Outline application with some matters reserved for the demolition of existing dwelling & erection of two pairs of semi-detached houses & associated works.

261 Aldwick Road Aldwick

Thank you for your internet representation made on 26th March 2018 which has been recorded as '**an objection**' with the comments as follows:

1060/DPA04

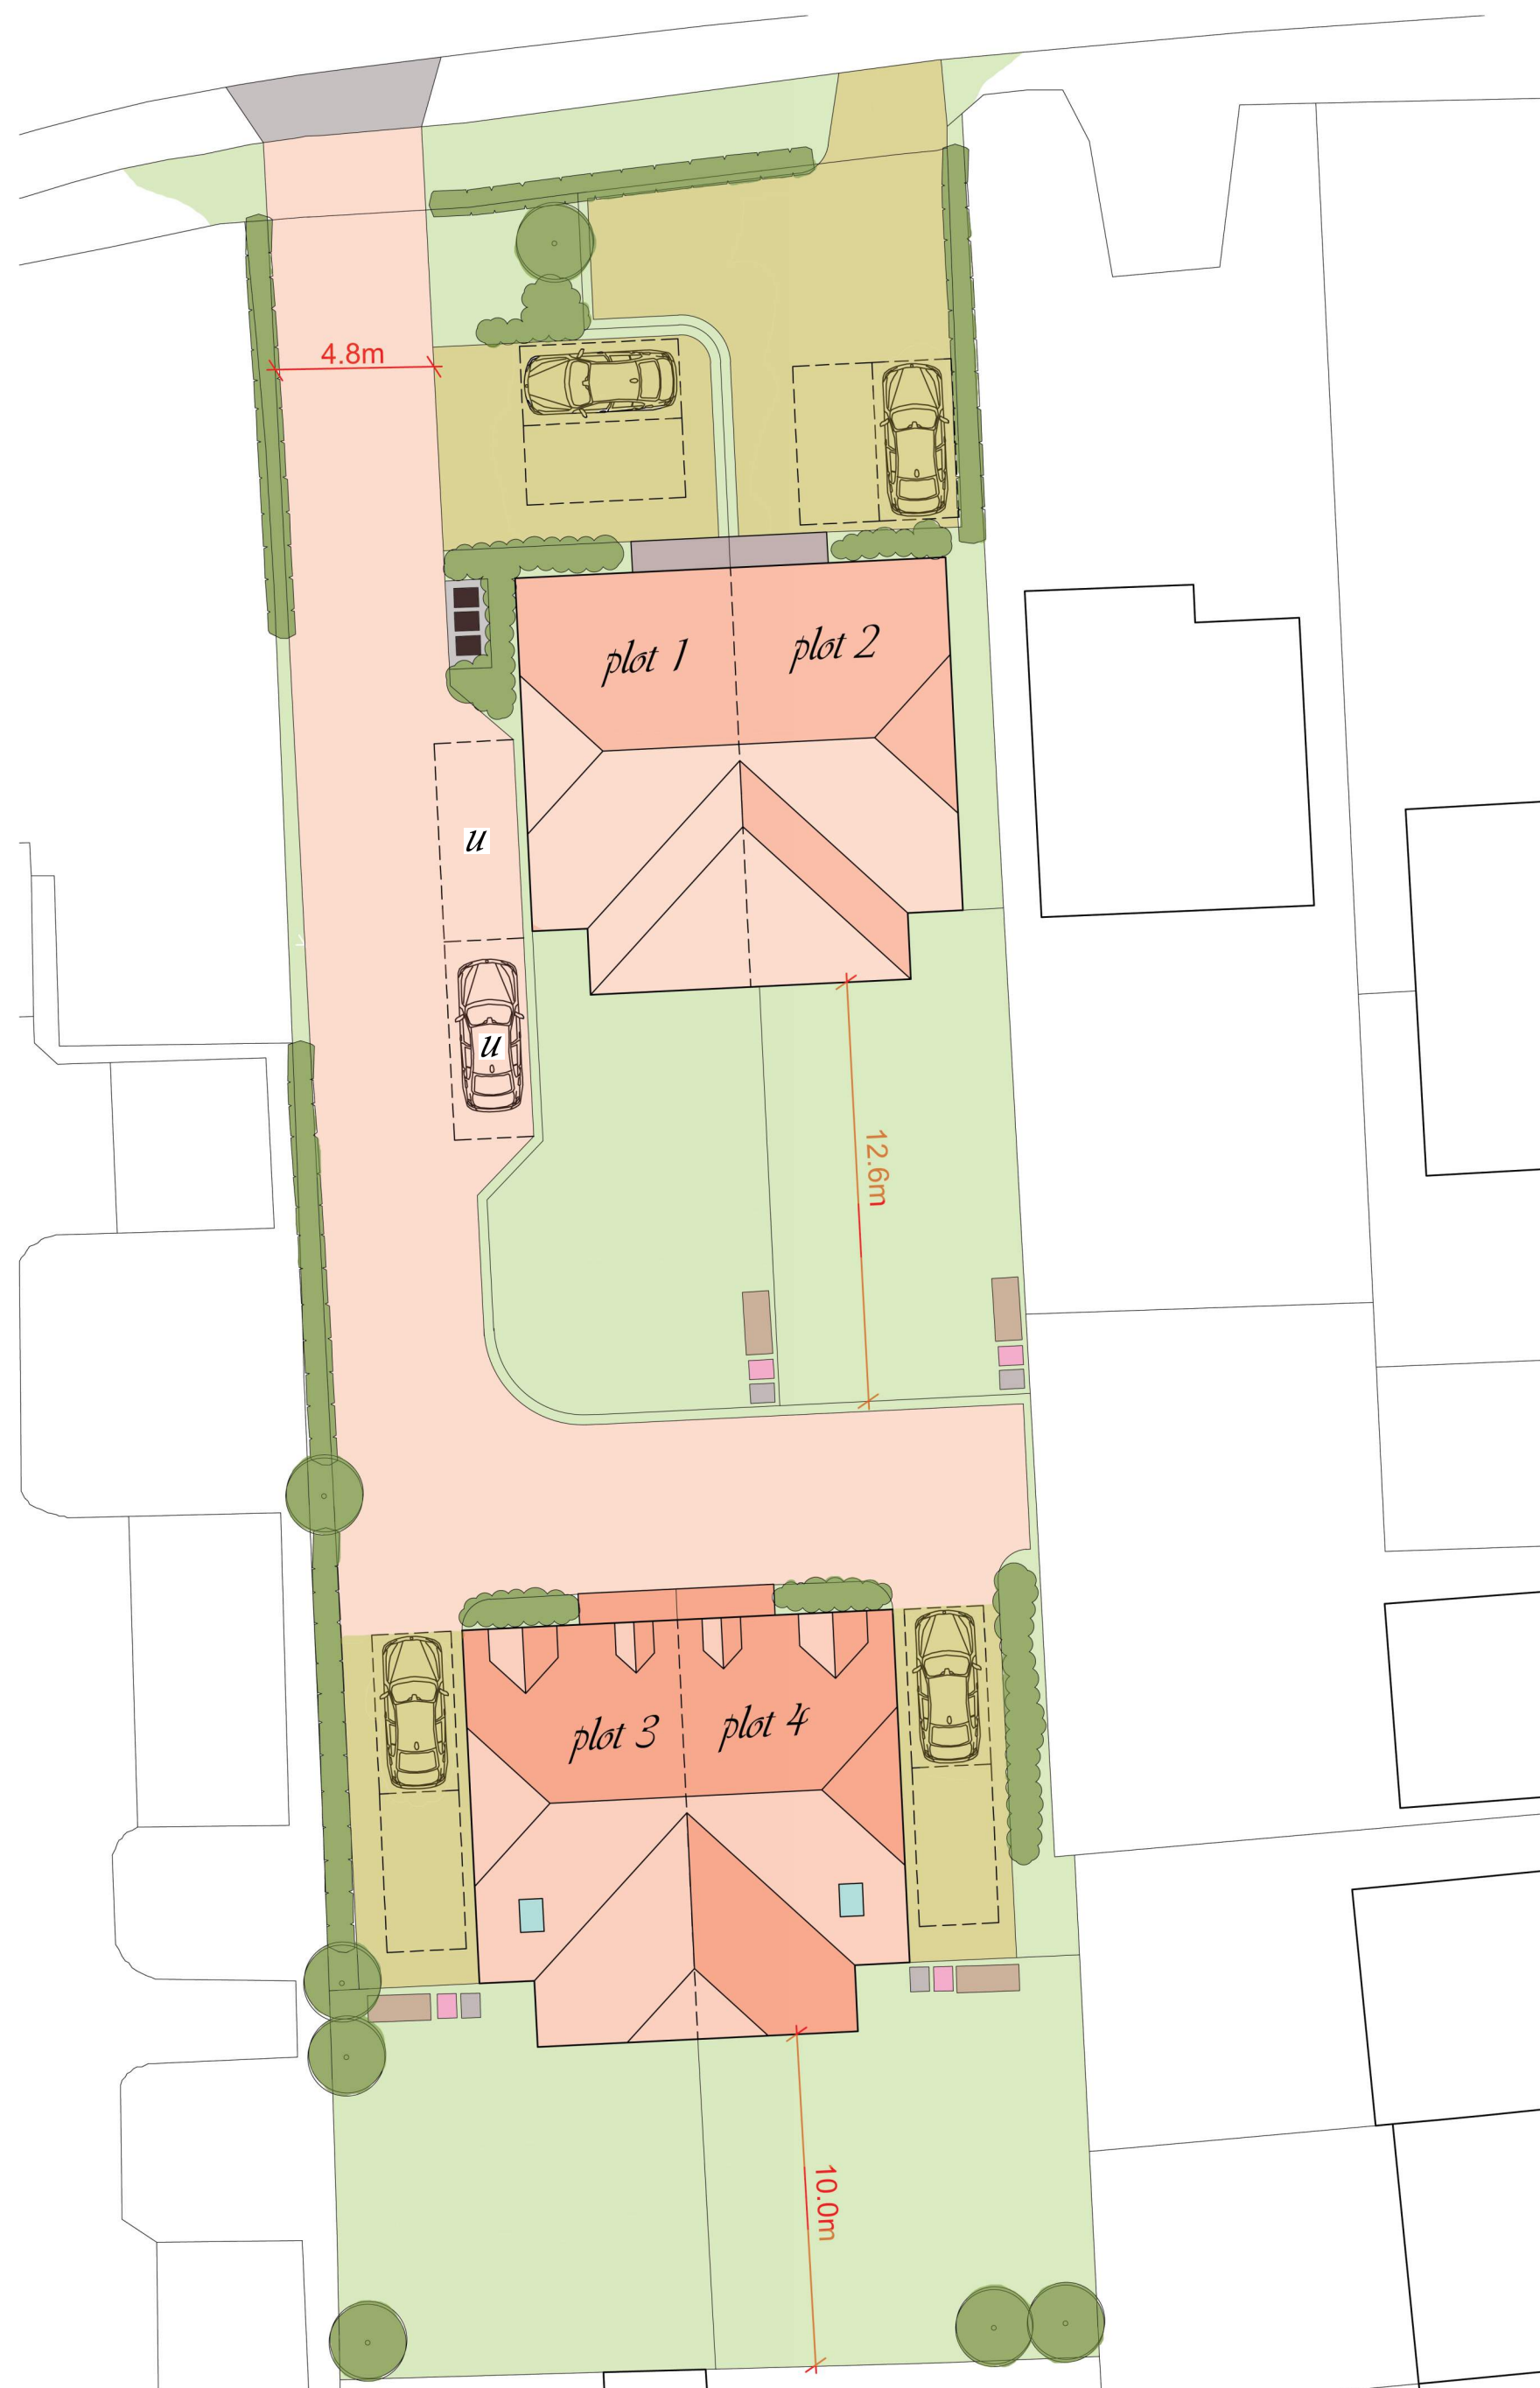
*We feel uneasy about the proposals for plots 3 and 4. The front elevations are shown in the plans, but not the rear ones. If there were to be windows facing our way on their first floors, and if the evergreen tree or bush were to be removed, which now blocks our vision of the site, upstairs windows of the proposed dwellings would look into our windows at the same height, which we would be an intrusion on our privacy.*

*Also it seems to us that there are too many dwellings proposed for the site. The parking and turning spaces seem inadequate for that number and if the proposal were to be implemented there would inevitably be increased parking on the Aldwick Road. This road is a busy one, which is already often effectively reduced in width during business hours by vehicles connected with the Kia Garage, a hundred yards or so to the east.*
